Please ask for: Ms Iqraa Malik
Email: iqraa.malik@terraquest.co.uk
Telephone: 0121 234 1390
Our Ref: EP/167/21/HH
Your Ref:
Date: 16th December 2021

Application for Planning Permission for Works or Extension to a Dwelling

Development: Erection of single storey rear and side extensions with mono pitched roofs and installation of fencing to front and side.
Location: 2 Vicarage Lane East Preston BN16 2SP

Block Plan

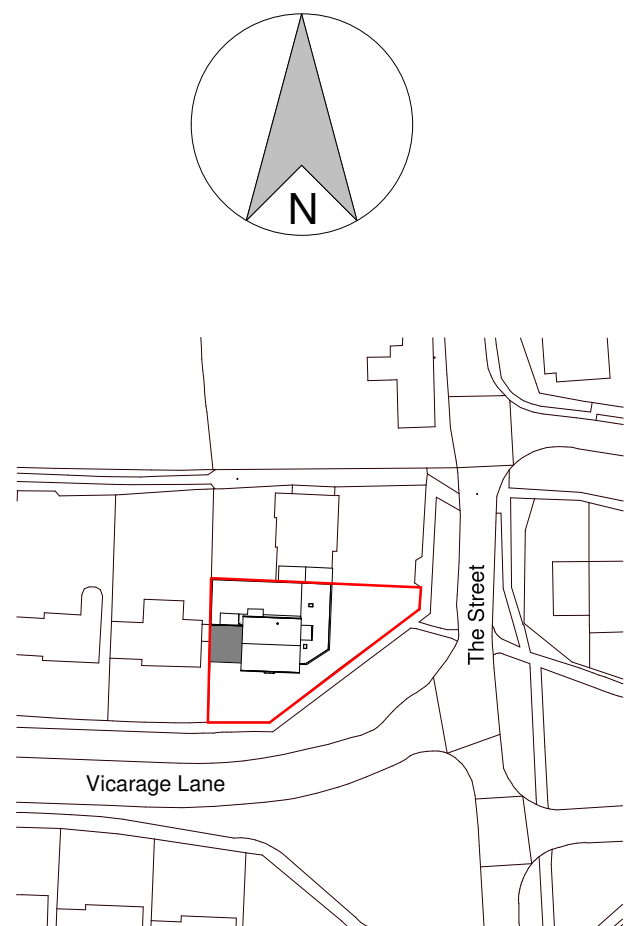
Block Plan

You are required to have dimensions from the proposed extension(s) to all site boundaries. Please amend.

Client	Mrs Grace Morgan
Project	2 Vicarage Lane
Sheet	Fence Elevations

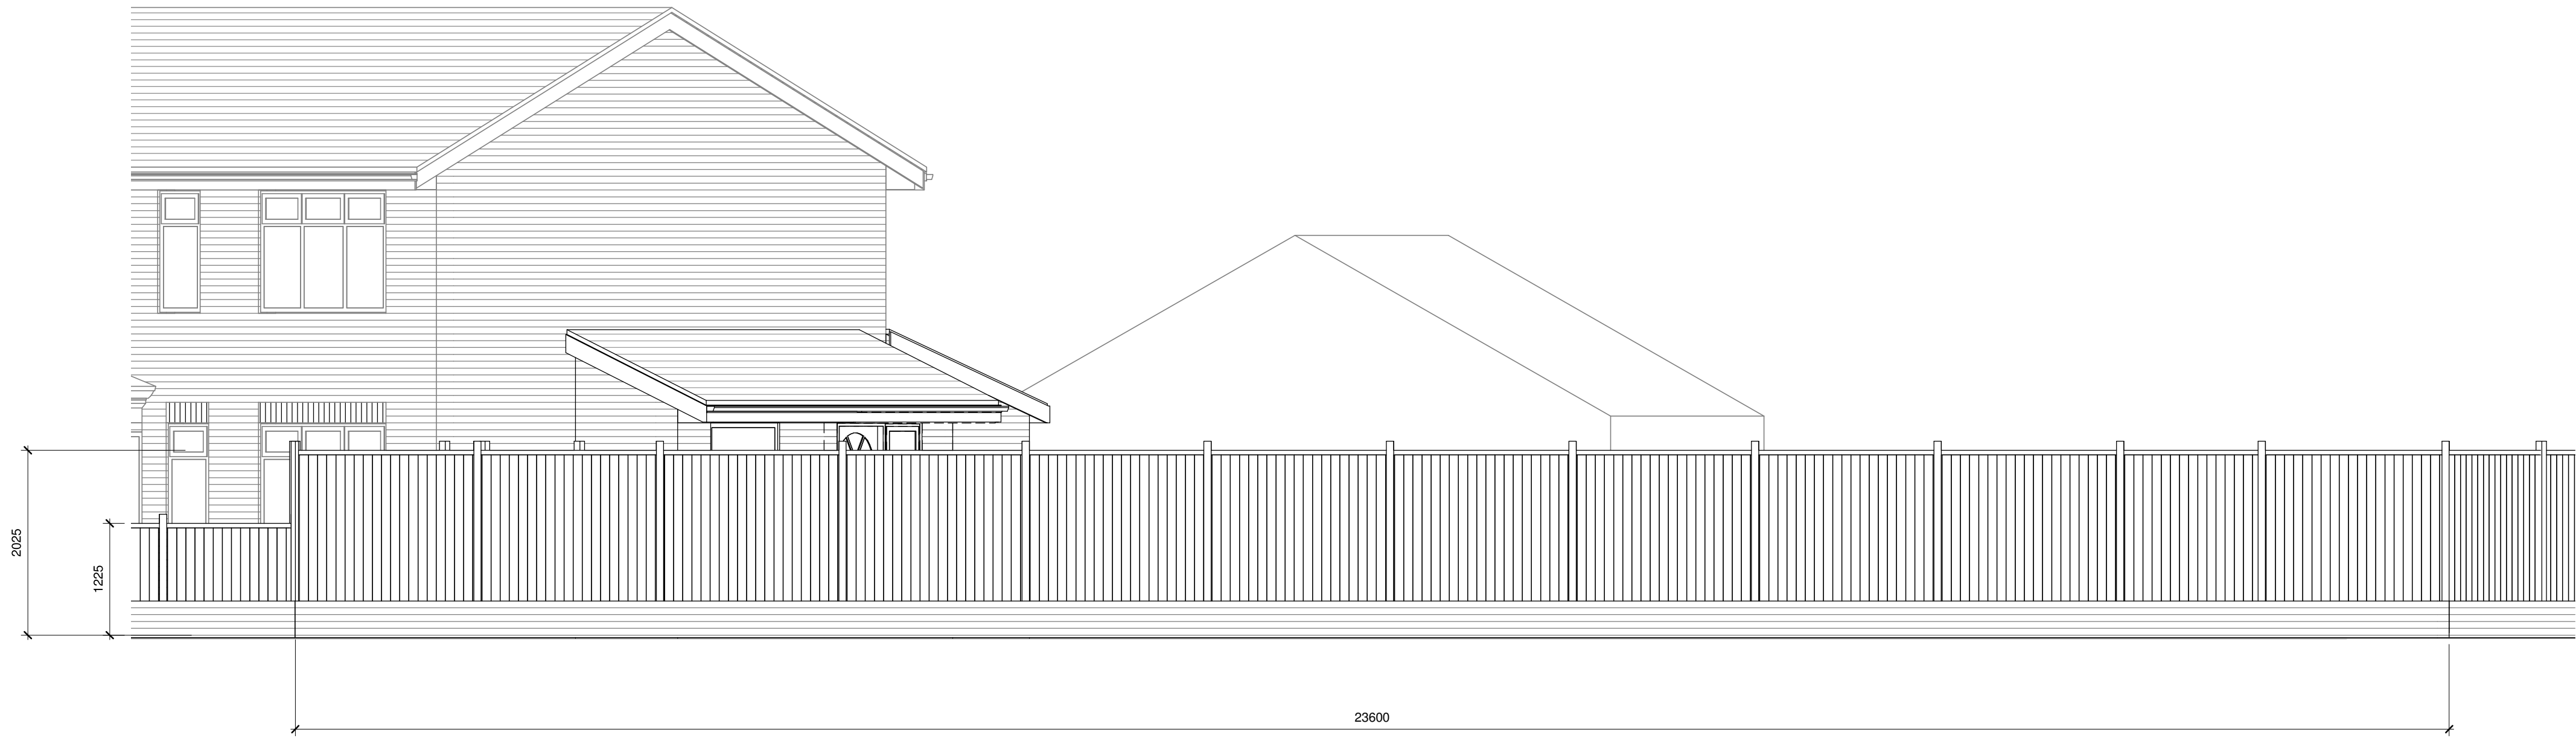
Elevations

Please submit the proposed fence elevations at a scale of 1:50 or 1:100. Further details can be found in the Validation Requirements List.
